Item No. **Report of the Head of Development Management and Building Control**

Address: 37 LAWN AVENUE WEST DRAYTON

Development: Installation of 8 solar panels on the rear extension.

LBH Ref Nos: 41150/APP/2022/3829

► Building 1

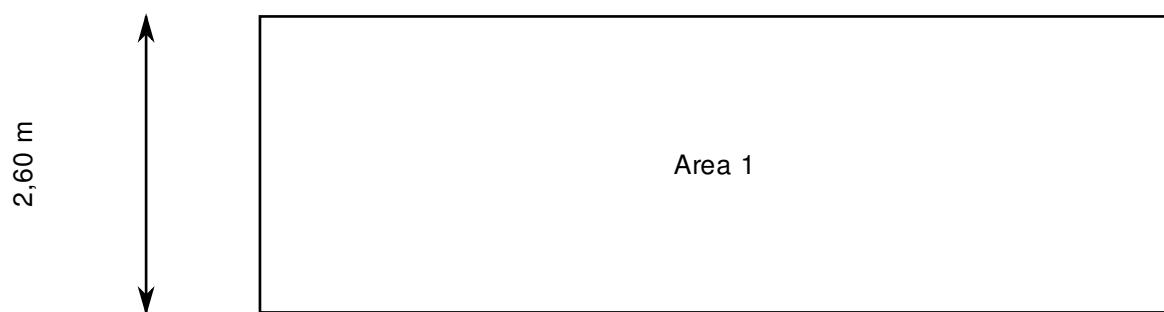
We do not want to stop moves towards a more self-sufficient electricity supply for this property but do not believe the solar panels would work efficiently at the very shallow angles shown in the submitted plans and elevations. In particular we are concerned by the proposal to erect an array of solar panels on the roof of the dormer as if they were set at the normal angle, they would be visible from the road - which we consider highly undesirable in this Area of Special Local Character. The panels proposed for the single-storey flat roof would probably also be visible from the road through the gap to the adjoining house if they were set at the usual angle. If permission is to be granted, there must be a condition imposed to ensure construction must be in exact compliance to the submitted plans.

The application site is located within the Garden City, West Drayton, Area of Special Local Character. The initially proposed scheme included solar panels on the rear roof dormer that would likely be visible above the main roof ridgeline from the street frontage. The Council objected to these panels on the basis this would harm the visual amenity of the streetscape and Special Local Character.

The revised scheme removes the proposed solar panels from the rear roof dormer and instead located 8 panels on the roof of the rear extension. These panels will be screened behind the original existing dwelling and will not be readily visible from the street scene, ensuring there is no adverse visual impact on the original dwelling or the surrounding area, avoiding harm to the heritage asset.
